H18-0112-26 2STAND – Ecology Comments

H18-0112-26 - 8-9 Grange Farm Hospital Road Sutton Bridge Spalding PE12 9YR
Conversion of redundant agricultural building for use as dog daycare.

Job Title Proposed Barn Conversion at Land Adj. 8-9 Grange Farm, Hospital Road, Sutton Bridge For: M. Stone	Date October 2025	Drawn by AK
		Checked by SP
Drawing Title Planning Drawing Location and Site Plan	Job No. SE-2379	Sheet Size A1
	Dwg No. 1000	Revision C

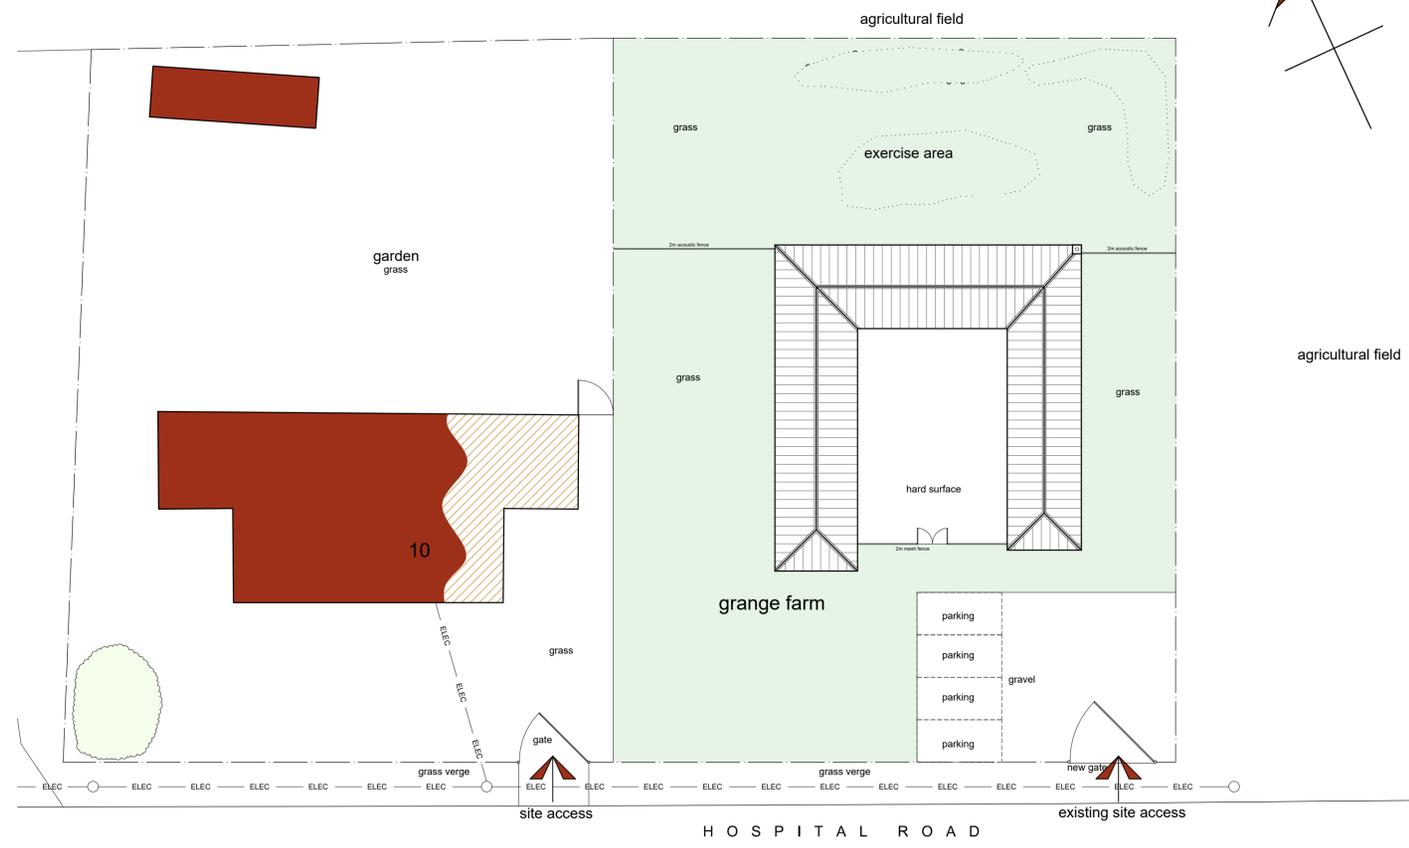
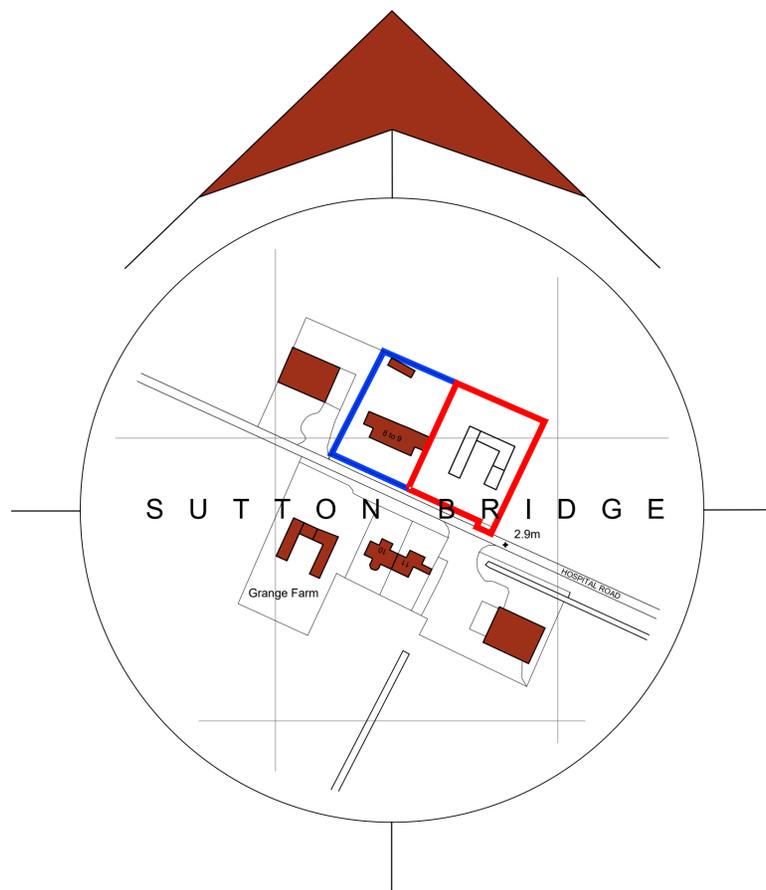
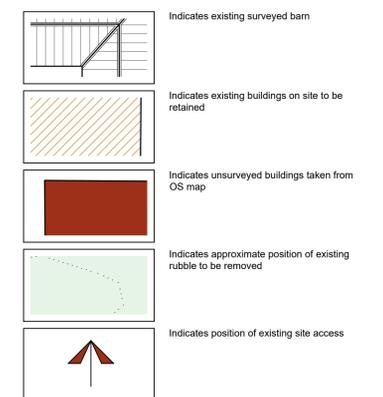
- Having reviewed this application, I believe that this application will require a Preliminary Ecological Assessment with a protected species survey (primarily Barn owl and Bat) to be provided pre-determination. The results from this PEA may reveal the need for more detailed species surveys.
- We request that the following habitat enhancements be implemented into the development plans.
 - We request that a minimum of 2 wall, tree or pole mounted bird boxes and 1 bat box are included on site to help mitigate habitat loss. These are required to enhance biodiversity and to be in line with Local Plan Policy 7.2.14.
 - In both cases, the authority requires the applicant to submit for approval sufficiently detailed maps that indicate the proposed location of bird/bat boxes on-site.
